**From:** Emma Avis [REDACTED]  
**Sent:** 20 March 2017 15:35  
**To:** Andrew Wood  
**Subject:** RE: Substitute amended Site Plan for informal advice at 1 Sea Drive

The LHA would raise no concerns to the extra vehicles associated with the development entering or exiting onto Sea Lane (the adopted highway). As you are aware Sea Drive is a private roadway and the LHA have no jurisdiction over it, the LHA can however offer observations: parking bays 1 & 2 would appear rather close to the junction and it could cause a collision if vehicles are reversing into or out of these spaces whilst vehicles are entering or exiting the Sea Drive junction. Could these two bays be relocated on the site?

JOB NO: 046
DWG. NO: 046/PL02
REVISION:
SCALE: 1:200 @ A1
DATE: 23/08/2016
DRAWN BY: RYAN GODFREY
CHECKED BY: MICHAEL T LUCAS
DWG. STATUS: PLANNING

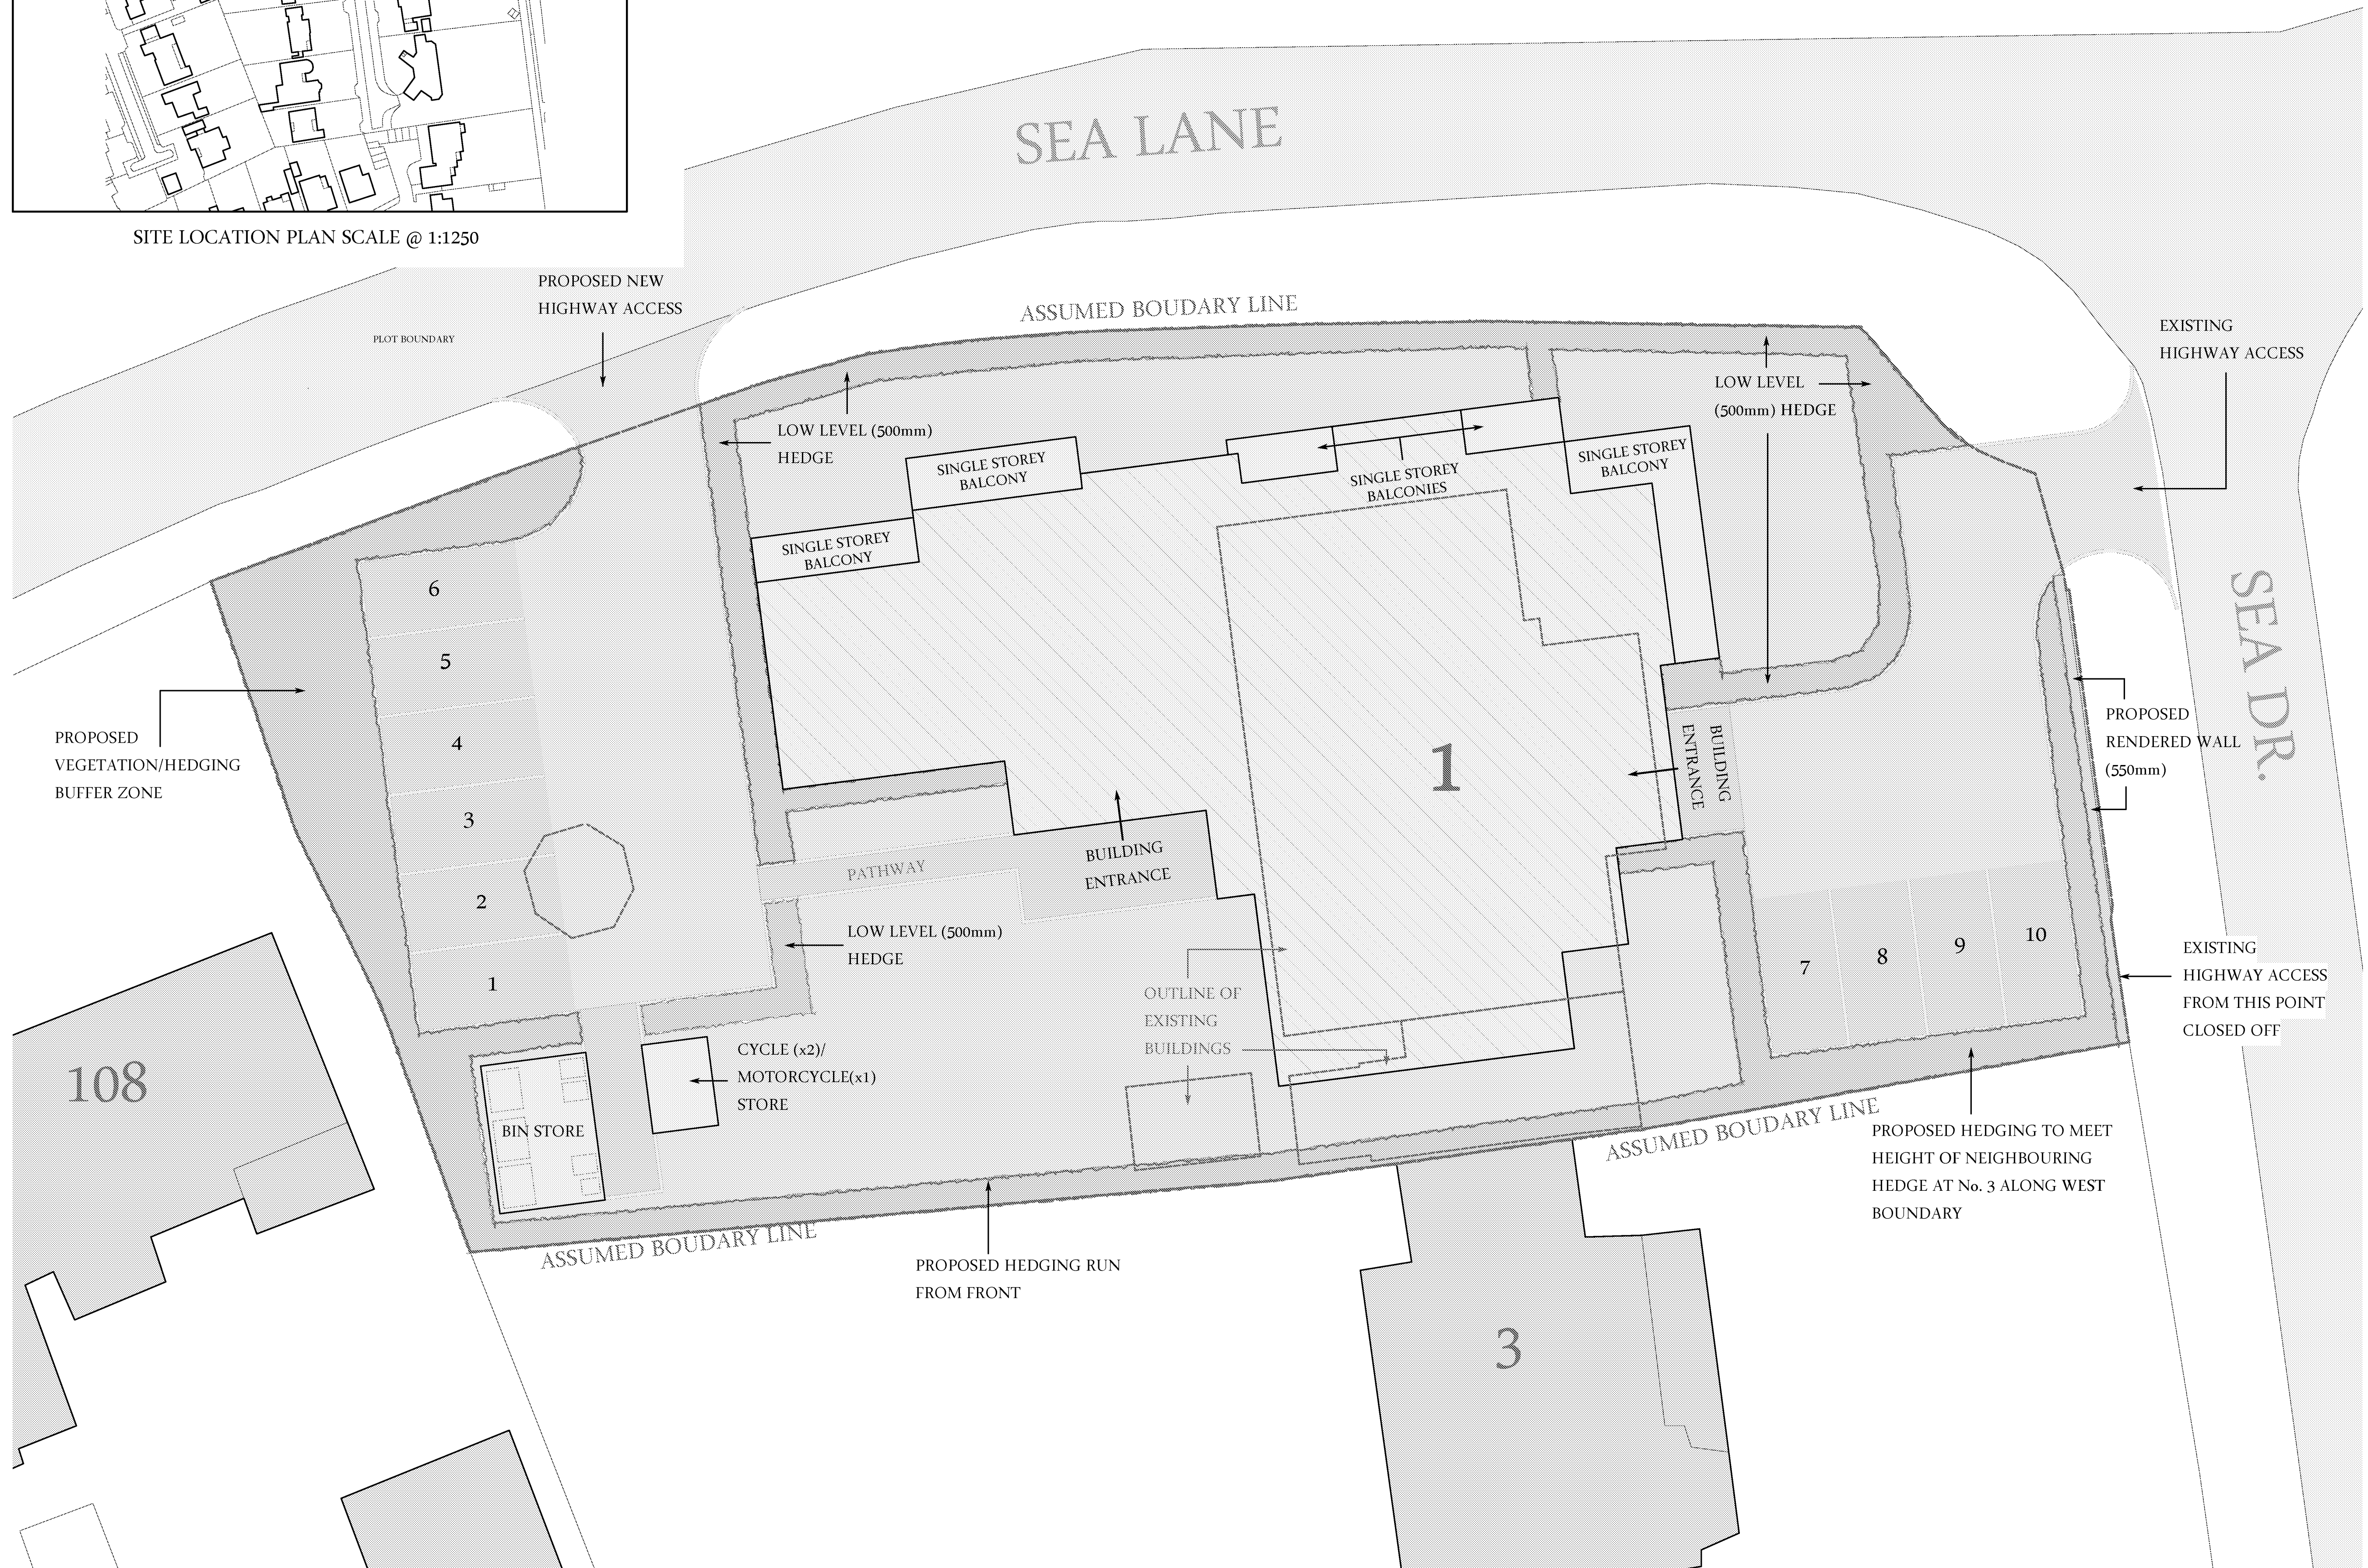
The access into the site and underground parking area appears to be 3m wide, this is not enough to allow two opposing vehicles to pass, shared access should normally be 4.5m, unless passing places are in situ; however given the frequency and low number of vehicular movements it is not considered that this would lead to any material impact on the local highway network that could be considered severe.

The underground parking area appears tight, vehicle tracking should be provided to demonstrate this is workable. In particular there is no turning head, it may be difficult for vehicles to get into and out of bays 6 & 7 and should a vehicle enter and all spaces are taken then it would involve them reversing out up the ramp, this is not ideal.
